ARCHITECTURAL DESIGN REPORT - ADDENDUM 01

Centre of Excellence in Agricultural Education

APPLICATION NO. SSD-1500146

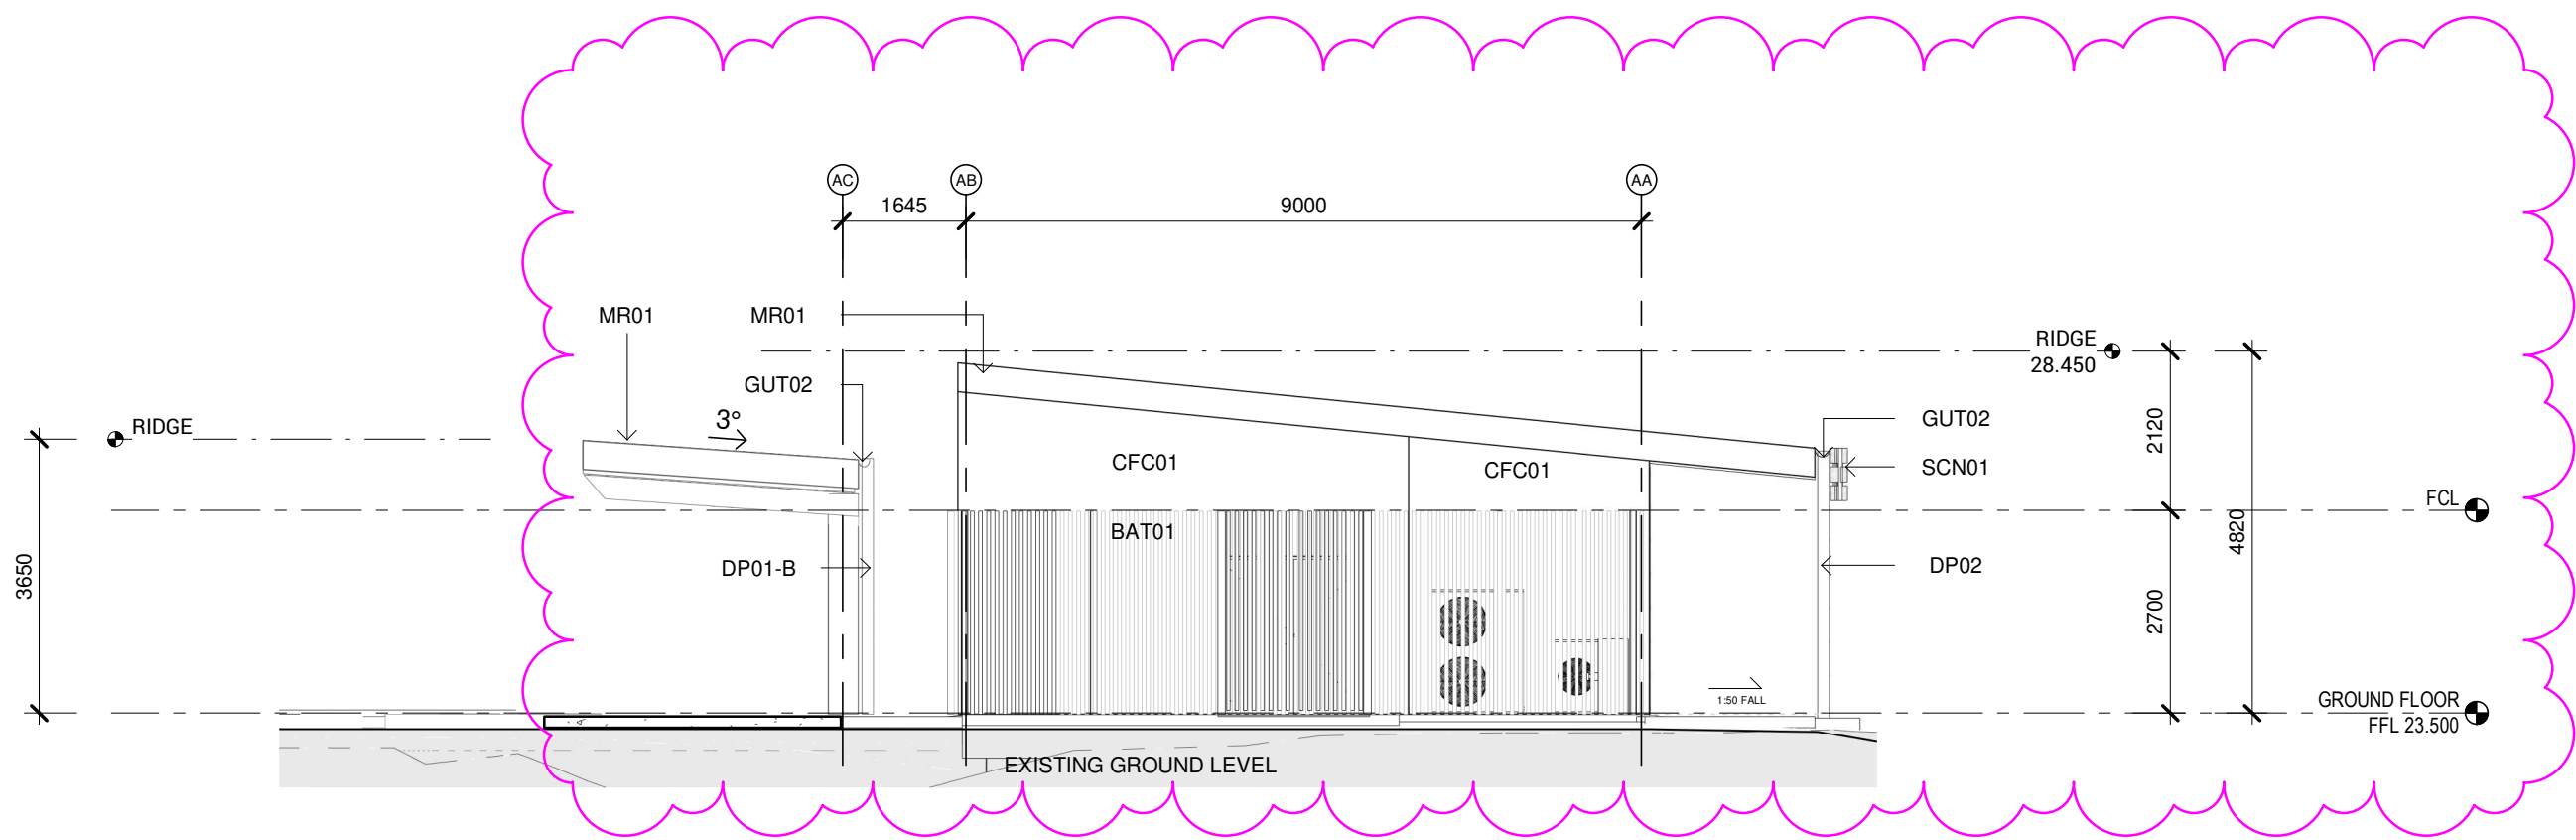
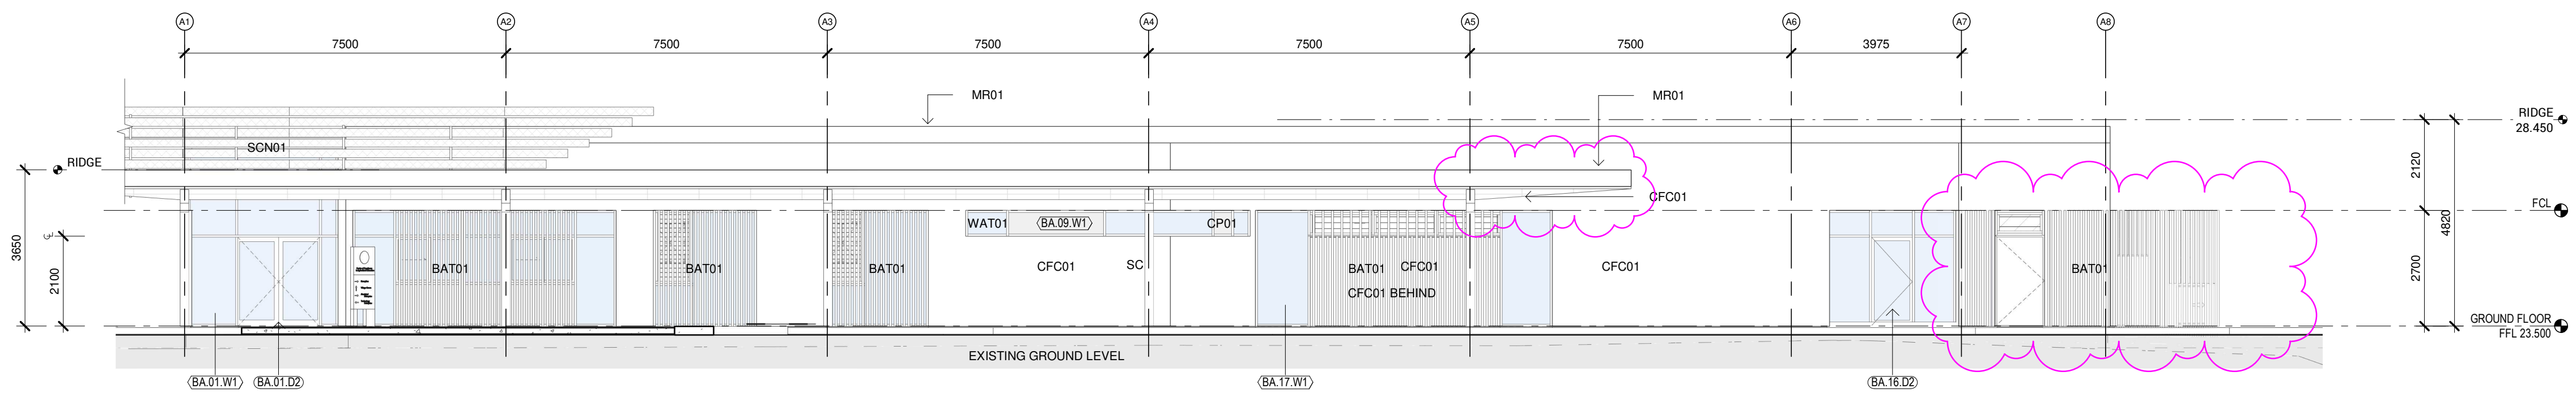
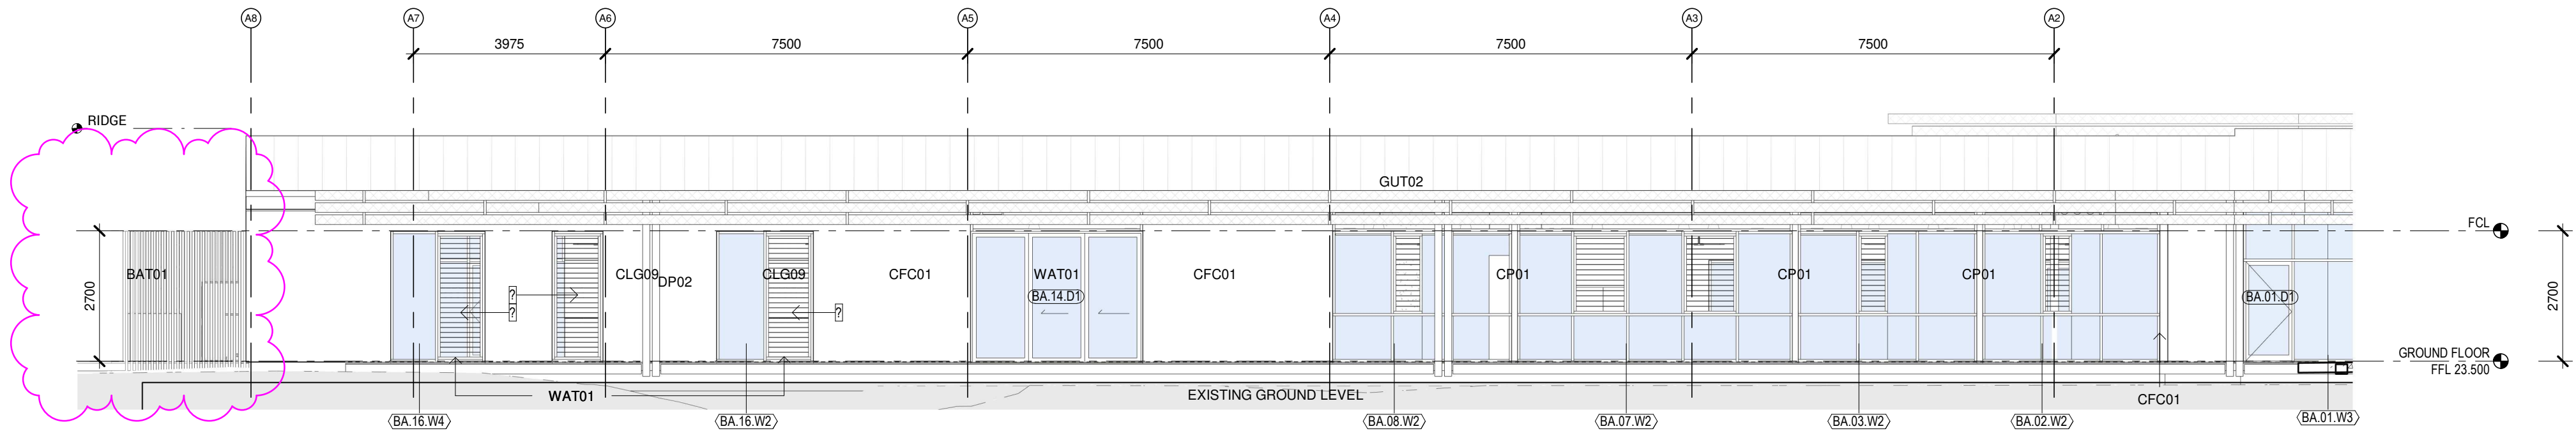
1. The proposed new substation for sole use by COE is no longer required
2. Relocation of COE's Main Switchboard Room (MSR) to the northern end of Building A to be closer to the existing WSU's Substation.
3. A small additional area has been created for the Staff Study to compensate the loss of usable area as a result of the relocation of the main switchboard room.
4. The relocation of the MSR results in a smaller fully enclosed building footprint area as highlighted in orange on the following drawing.

2 BLOCK B - NORTH ELEVATION 1
1 : 100

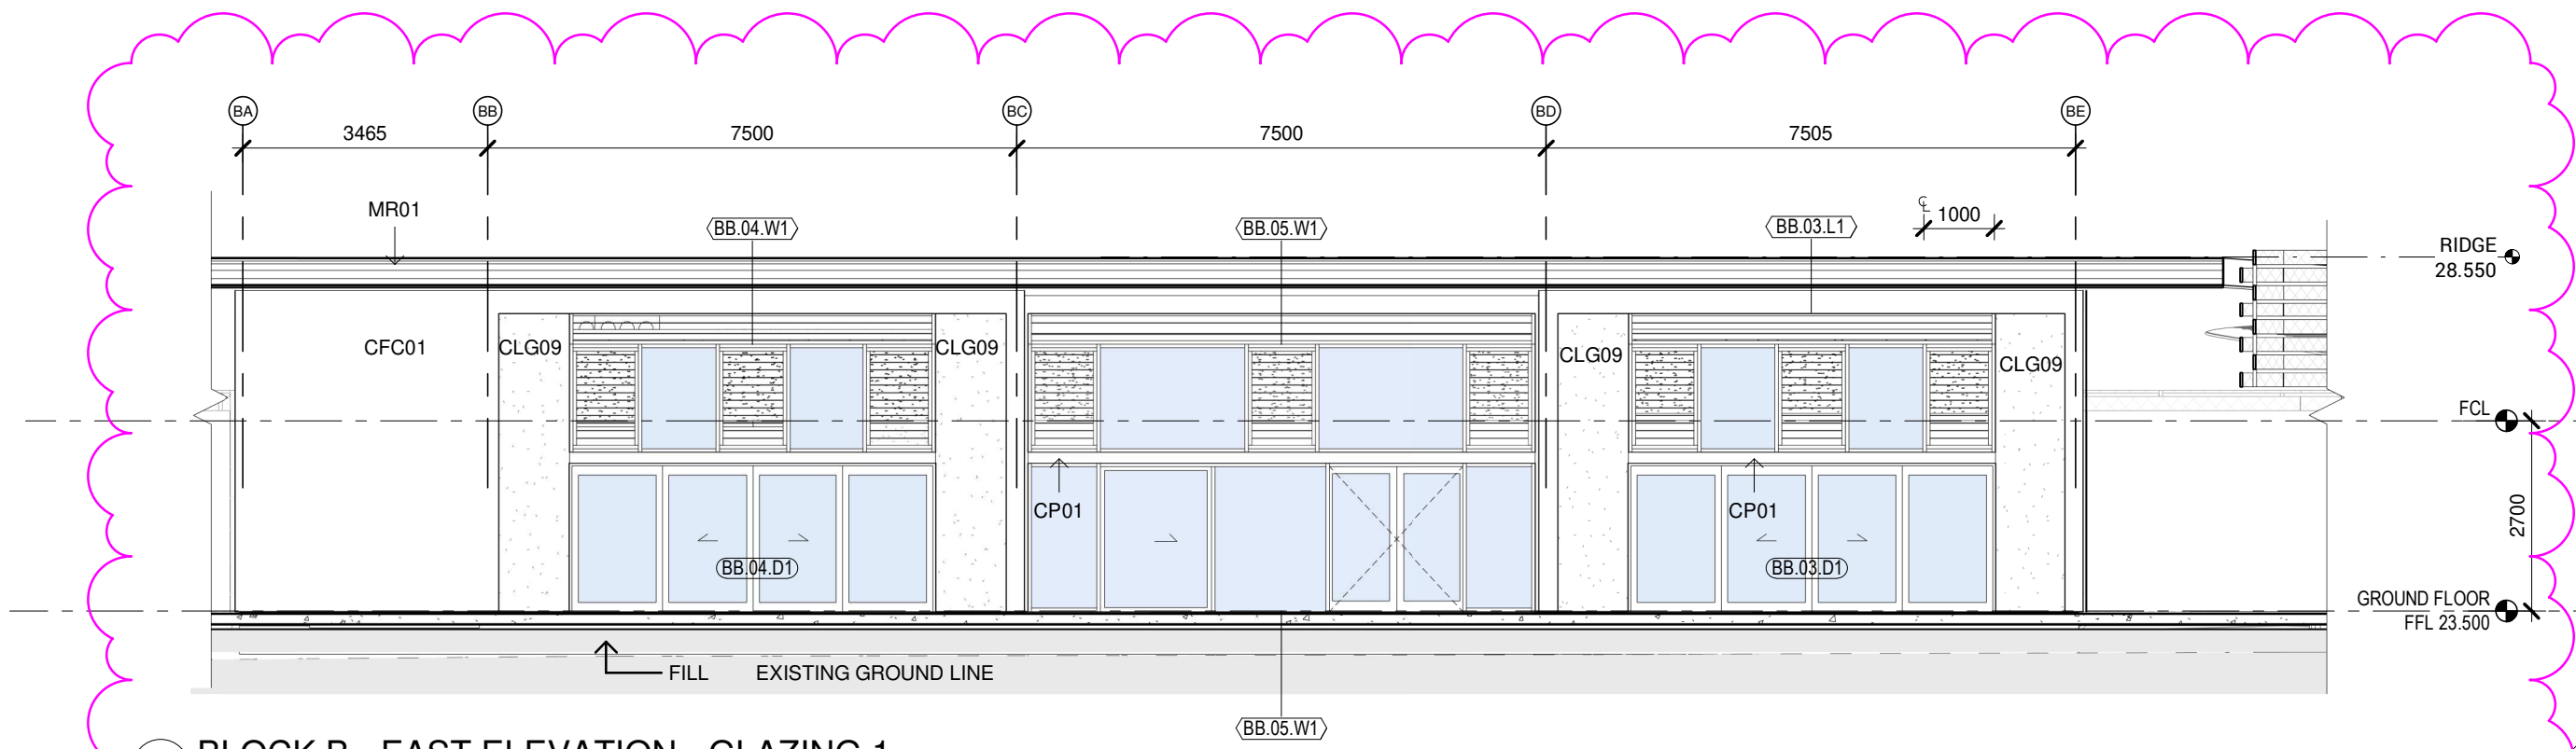
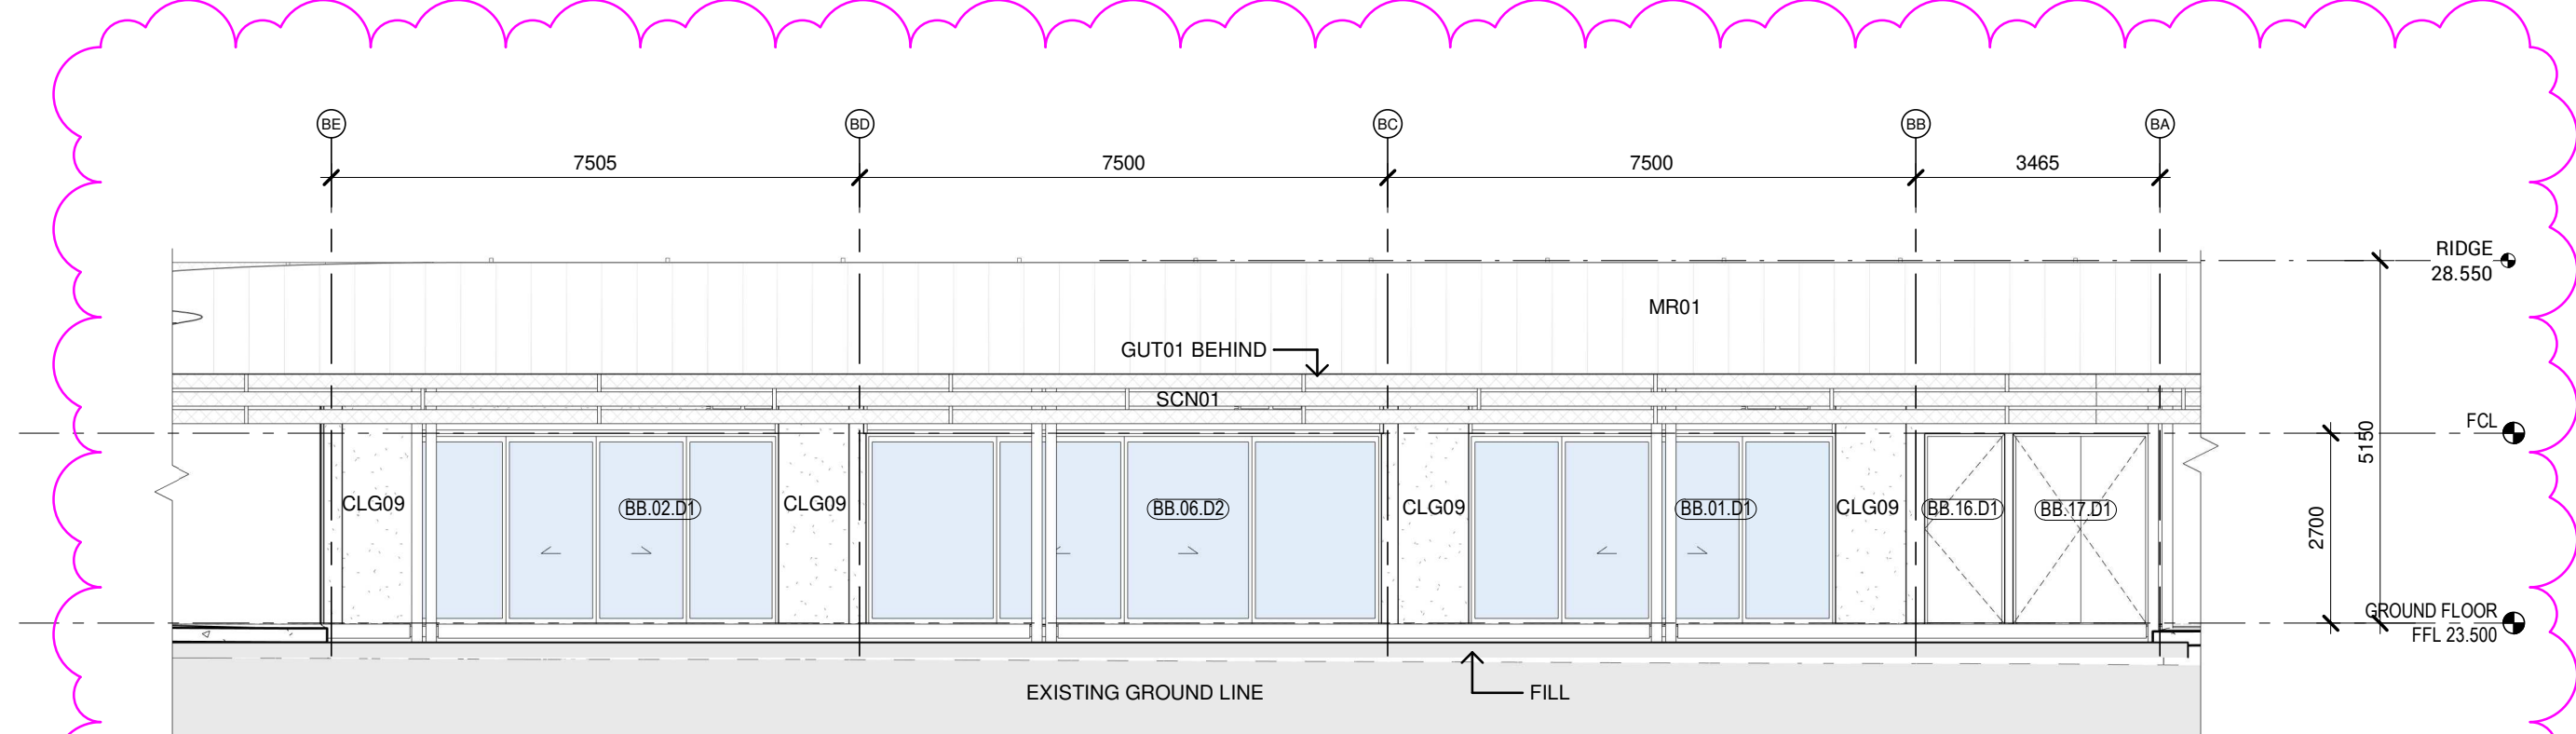
The three learning blocks, Building B, C and D, have received 15% reduction of the glazed area. This improves the overall structural design by providing additional structural support zones along the building facades. The following highlighted area of the building elevations illustrate the proportion of glazed façade that has been replaced with metal cladding with batt insulation.

1 BLOCK C - NORTH ELEVATION 1
1 : 100

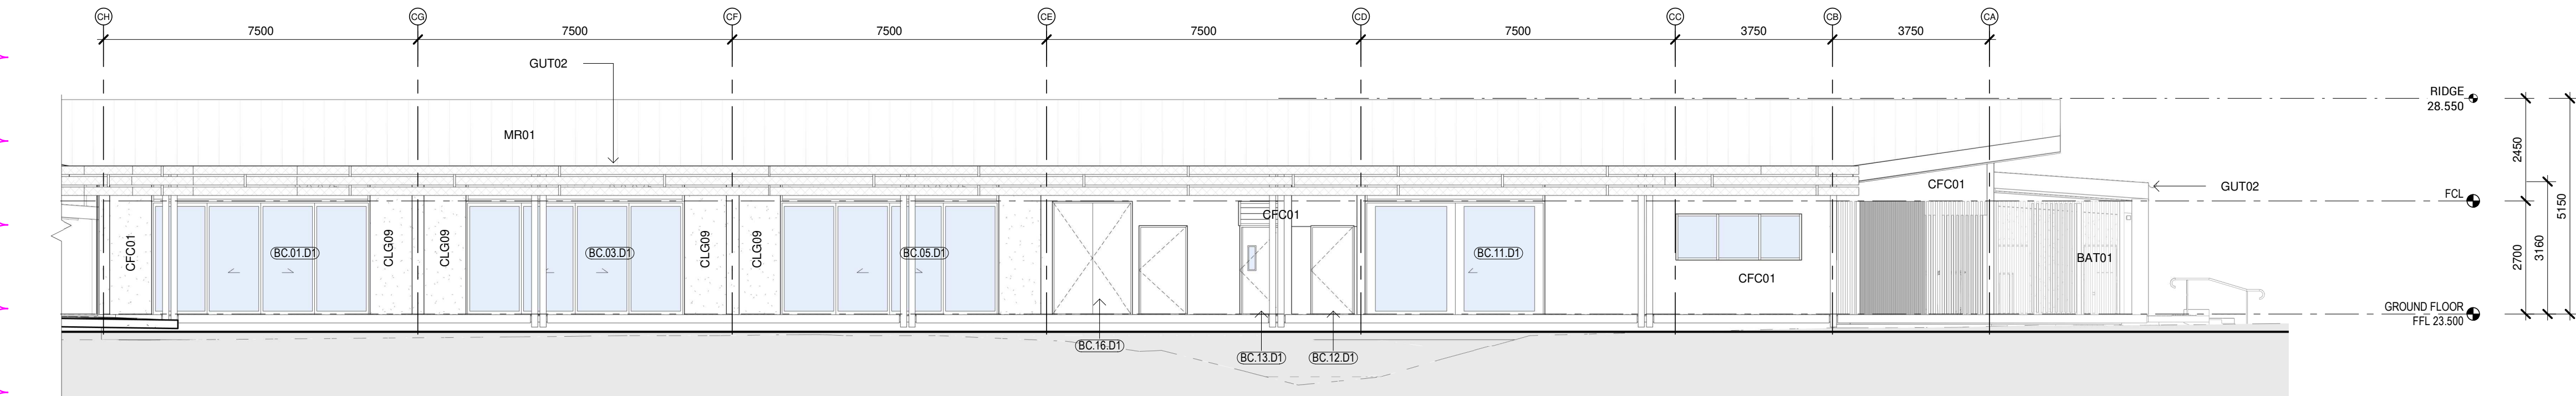
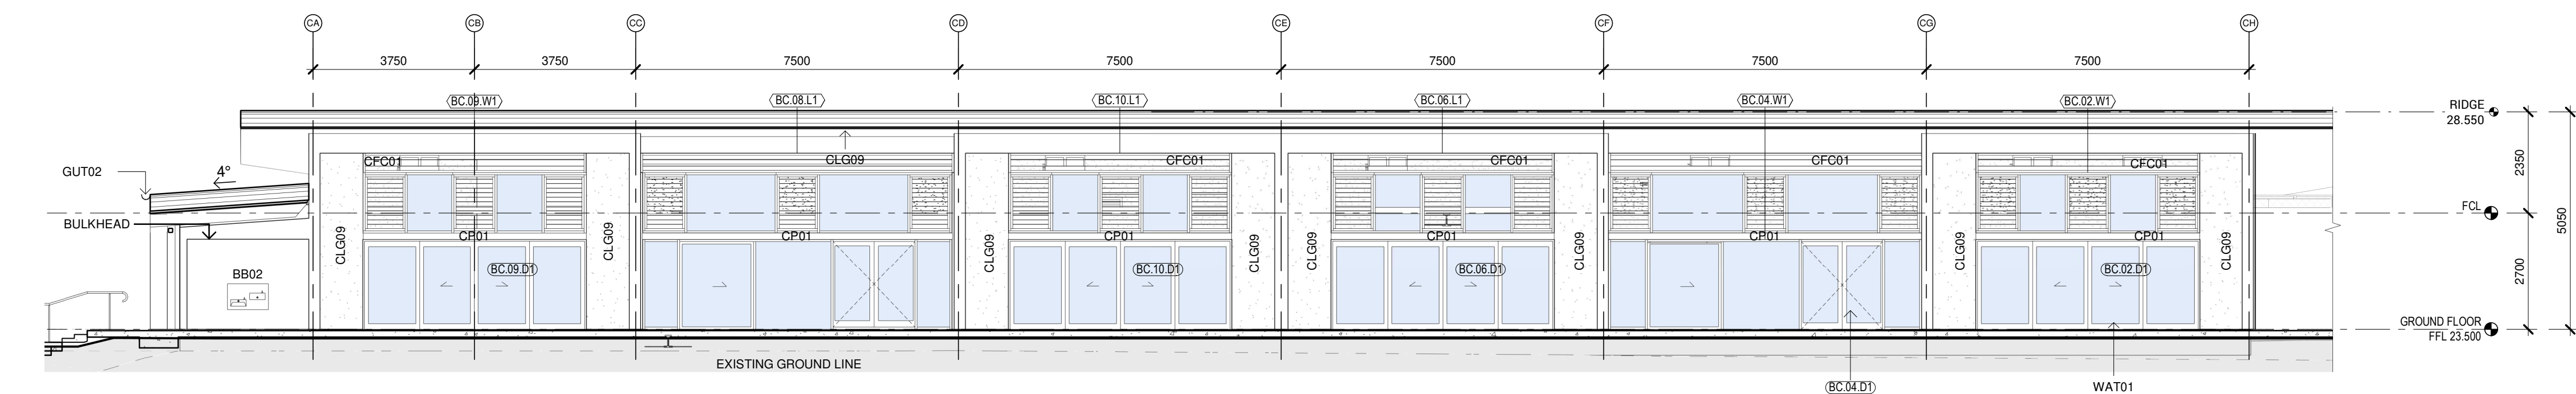
1. Additional recessed façade alters the south elevation of building C and south façade of building D
2. The functionality of the science area in building D will significantly improve by flipping the Botany/ Zoology with the neighbouring Practical Activity Area. This provides the opportunity for better daylight harvesting & ventilation into the Botany and Zoology.
